# The Hon Shelley Hancock MP

November 16, 2016

Re: DA 485-12-2002 Mod 1 - Modification to Residential Sub Division at  
Nadine Street, Sanctuary Point

TYPICAL 5m ROAD 01 CROSS SECTION
SCALE 1:50

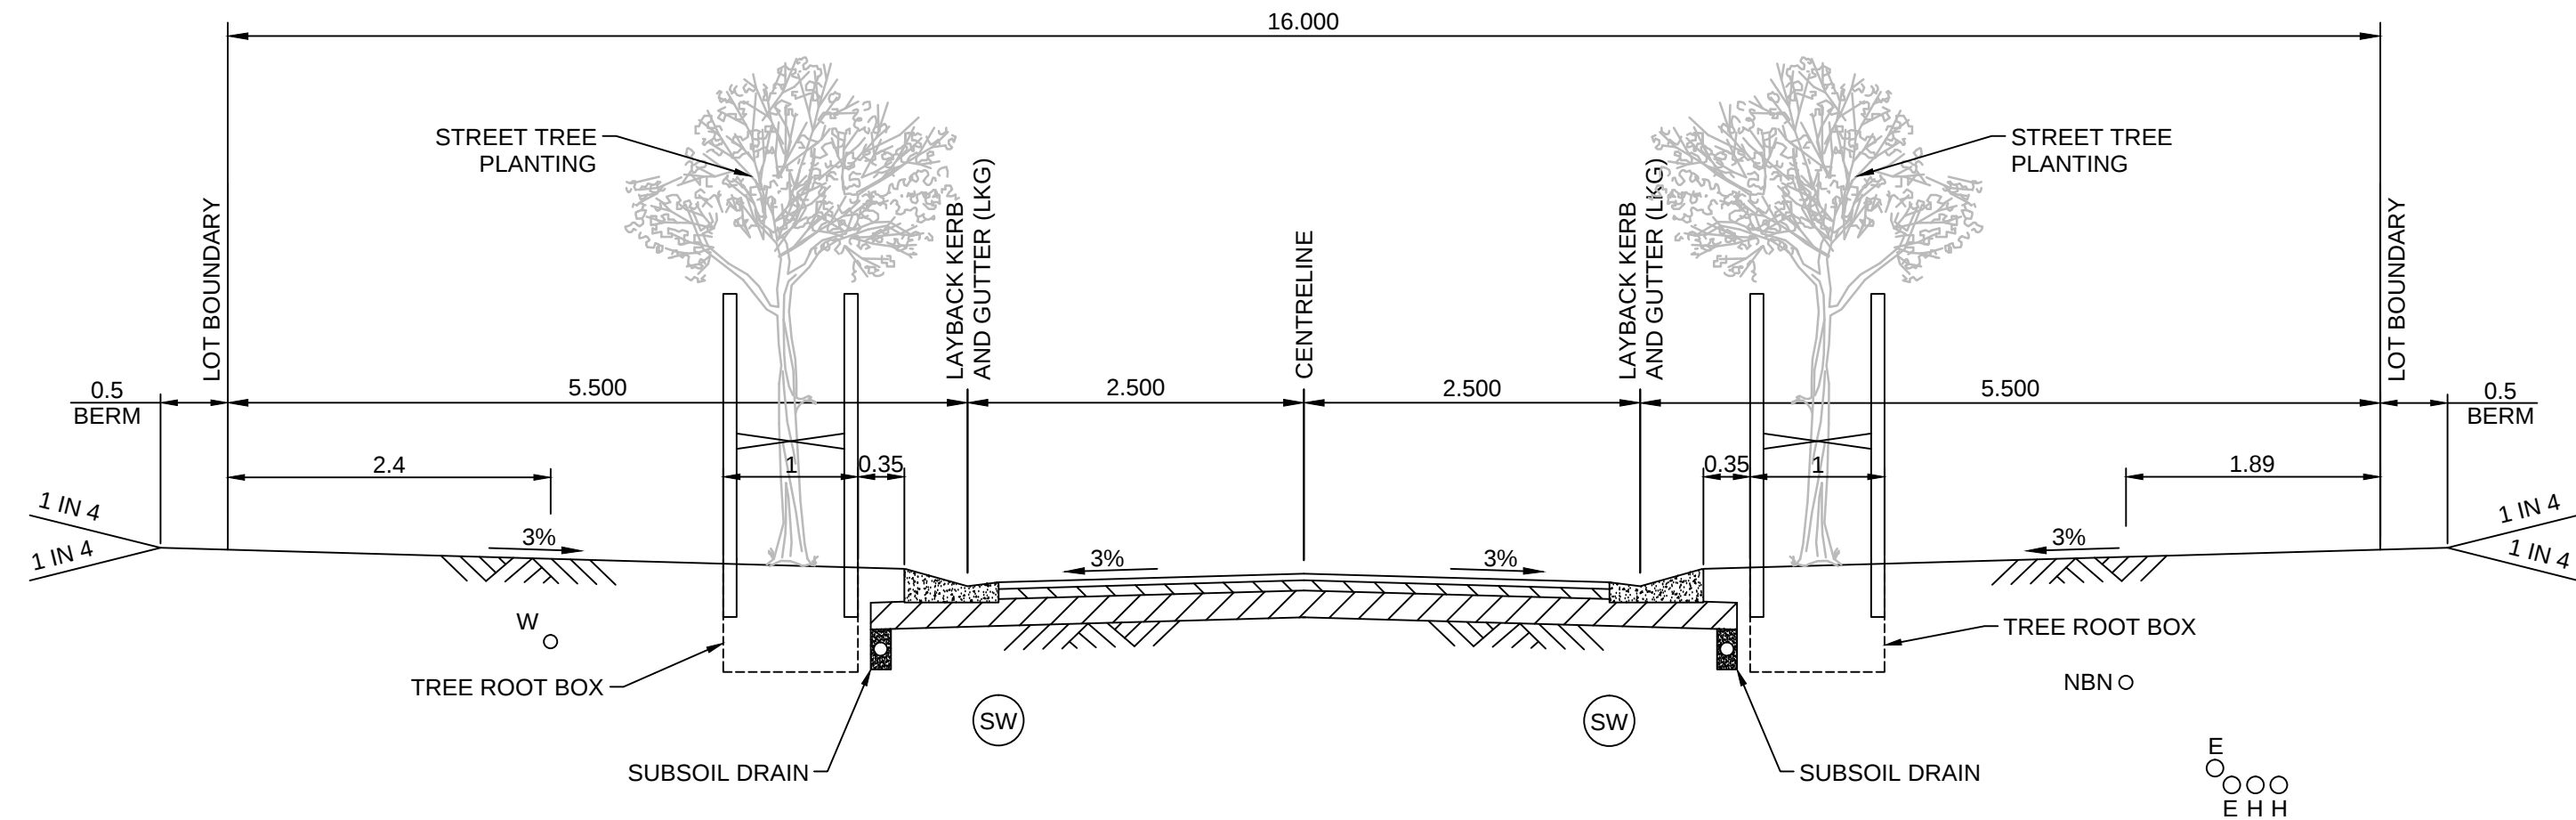
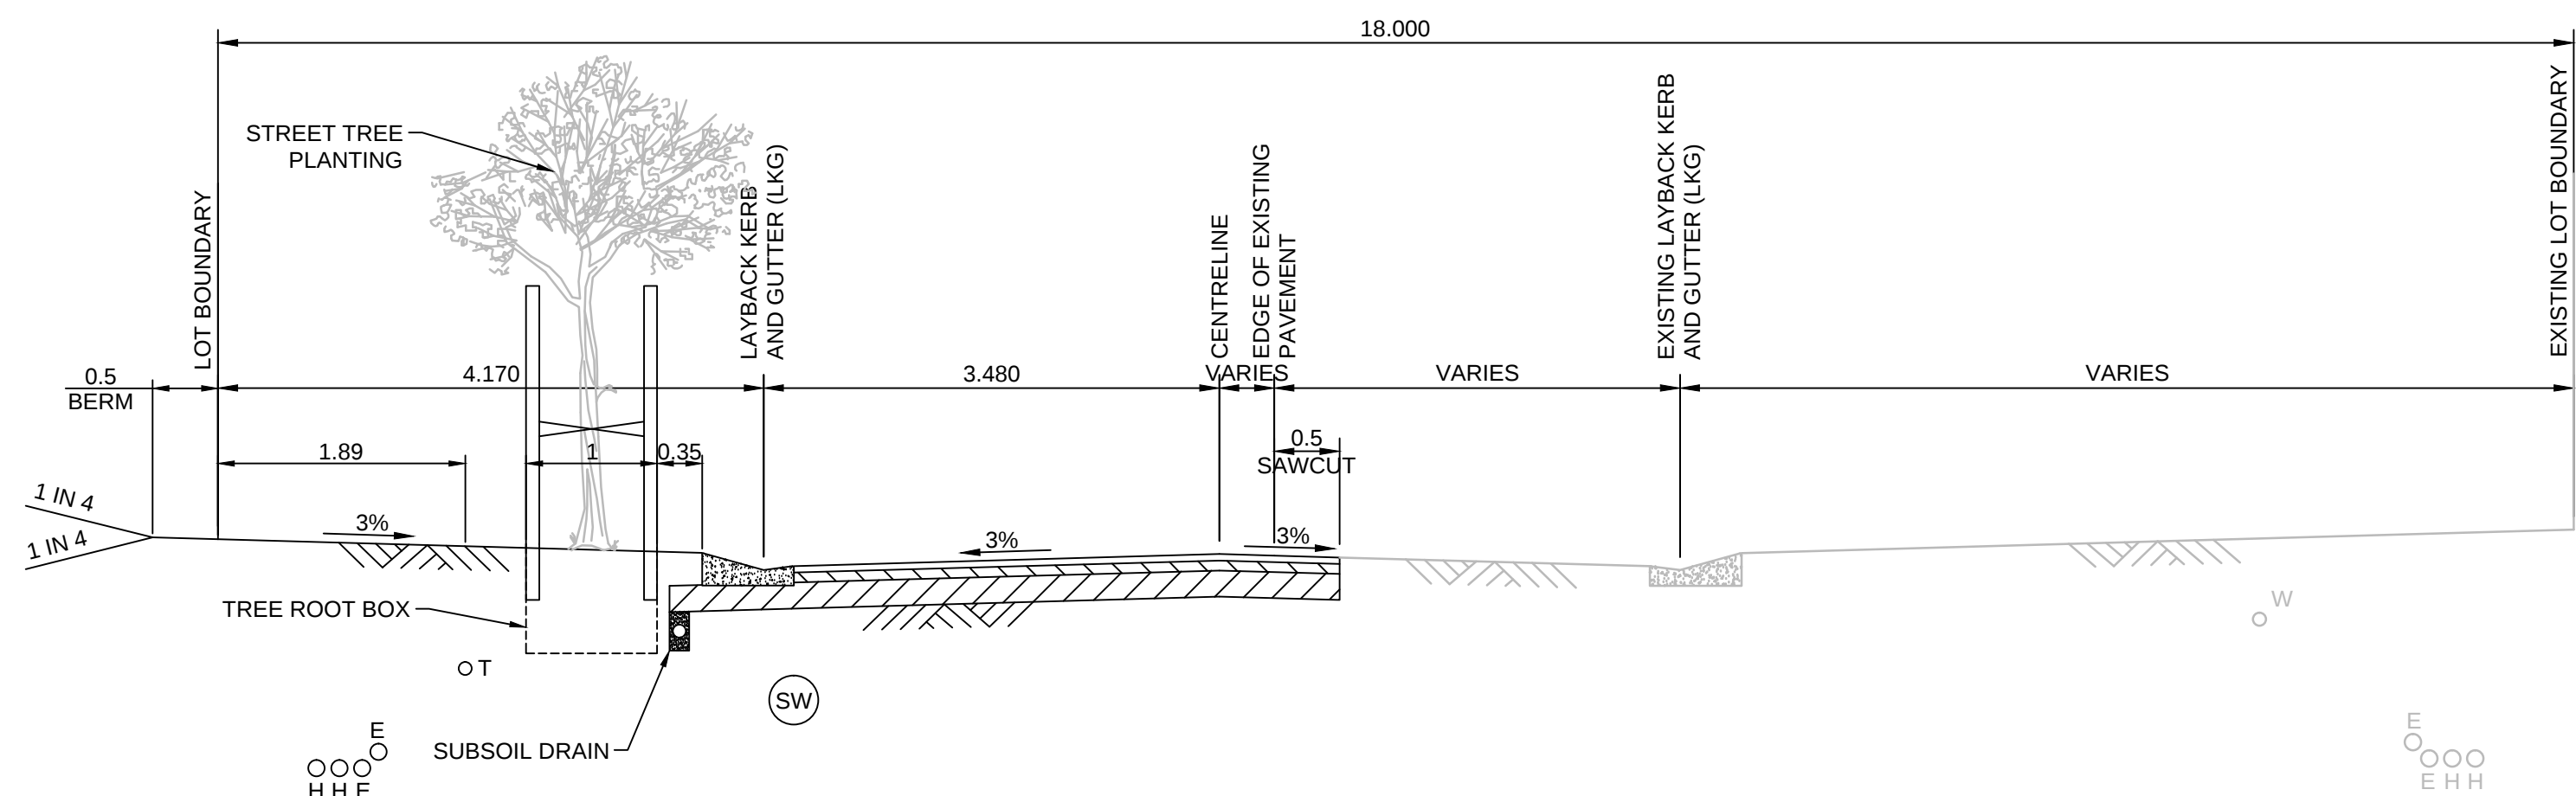
Concerns have been raised regarding the removal of the detention basin, that the revised width of the local roads will cause traffic and safety problems and that smaller block sizes, denser housing and hence population will add to the strain on local services and facilities.

- The proposed streets are too narrow and there are no footpaths to provide safe walking conditions especially during wet weather other than to walk on the road. Is it going to take a child or adult to be hit by a car to have these narrow roads banned? I live on one so I know from experience how dangerous they are when two cars passing have to drive up on the gutter and grass to pass each other. Also who is liable to repair the gutters when they are broken due to cars and trucks constantly driving over them?

PROPOSED RESIDENTIAL SUBDIVISION

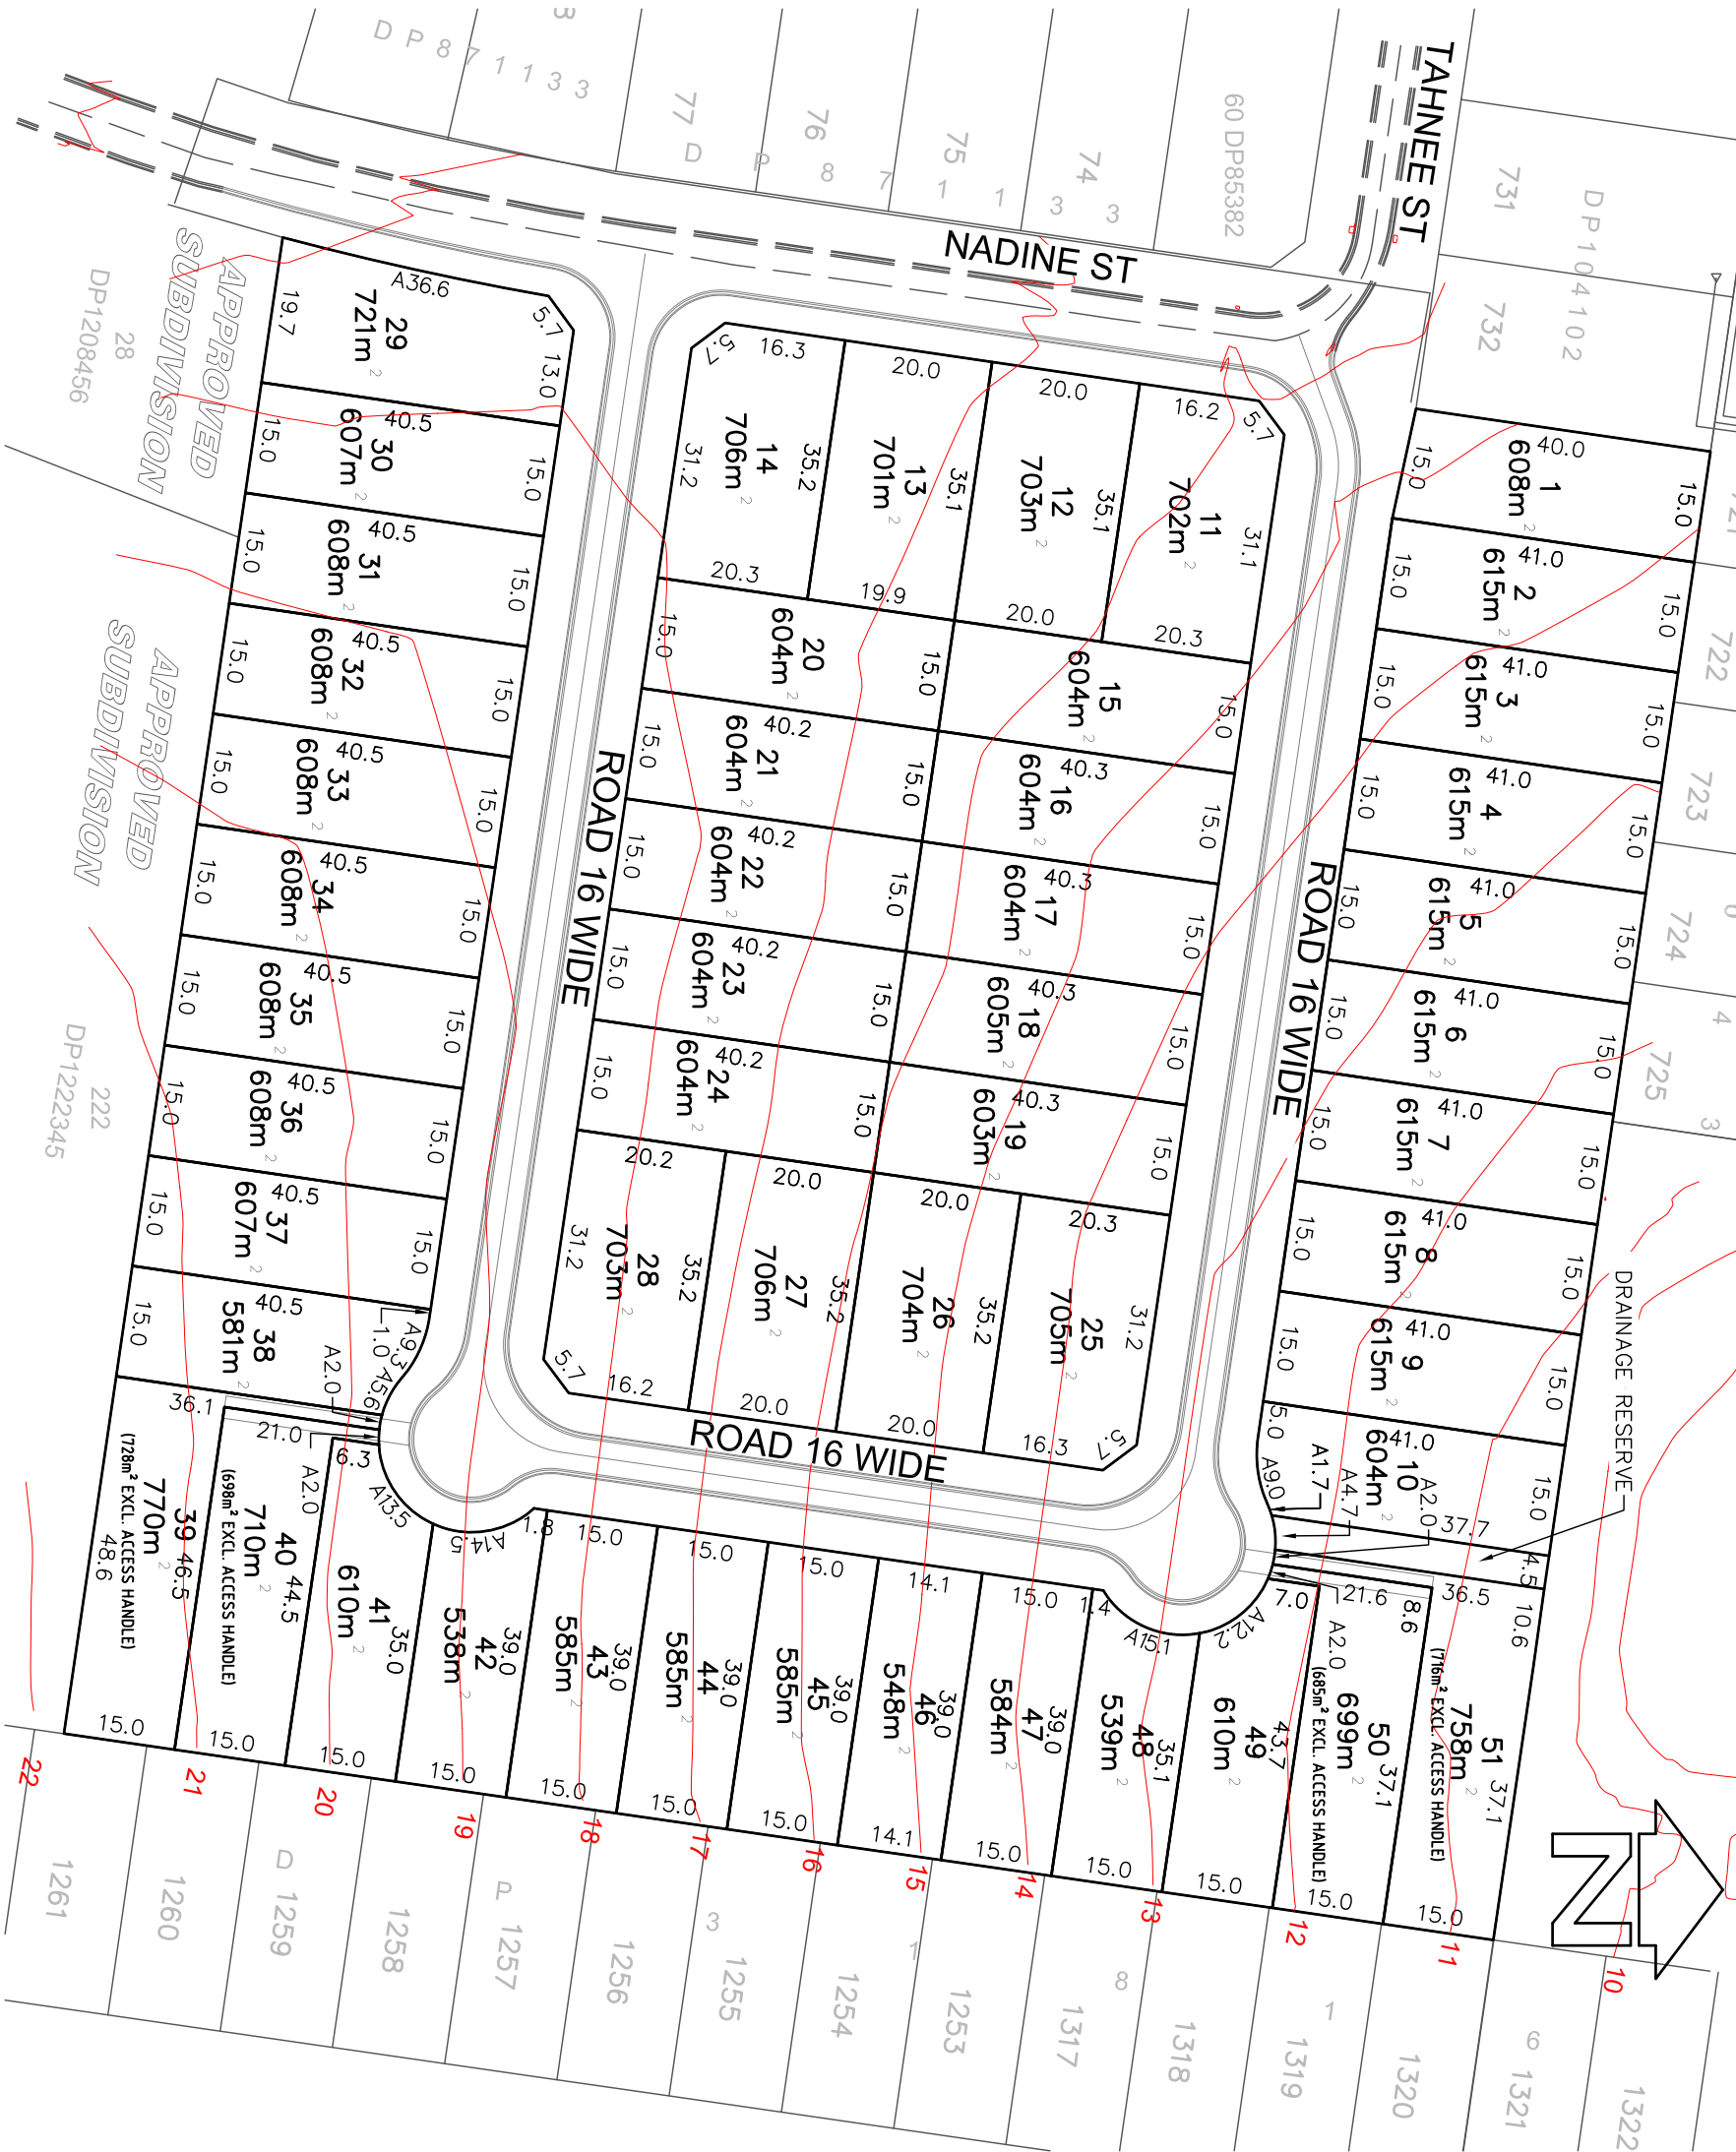
Several residents have stated their acceptance of the original sub division plan comprising 39 lots and 18 metre wide local roads. They have now expressed concern to the increased density of the amendments proposed and that the modifications are out of character in this coastal village.

1. Drainage problems. This land currently flood in normal rainfall . It will be considerably worse with extra housing.
2. Exiting wildlife kangaroos, possums, birds, snakes have nowhere to go
3. Narrower roads We have seen what has occurred in Voss Drive an d Maxwell crescent and the like with narrower roads and these roads appear to be smaller.
4. More houses mean more cars more pollution
5. During construction and clearing of land what compensation is available to residents for (a) house cleaning dirt and grime (b) washing on line.

- The amendment is seeking to delete the stormwater detention basin completely. Having lived through several major rain events backing onto the above site I can assure you getting rid of this detention basin will cause major flooding of existing and proposed blocks. We have experienced flooding of our property from runoff already (I have video and photos), the soil in this area is very dense clay therefore doesn't allow for soaking in of heavy rainfall.

- Making the block sizes smaller is only promoting denser housing which is totally out of character for the local area. This is a semi sleepy coastal suburb NOT the Sydney basin where high-rise, high density housing is required due to the population. People that have moved here did so for the sole purpose of getting away from that.

Of concern to all property owners would be the measures undertaken to control the normal and also extraordinary rainfalls run off from the property if the originally applied for and approved drainage allotment was to be removed to allow for more allotments.

If measures to remediate the water drainage particularly down the existing sewerage line easement adjacent to our rear boundarys are not taken I would not be in favour of any change to the current approval, particularly the deletion of the detention basin for storm water.
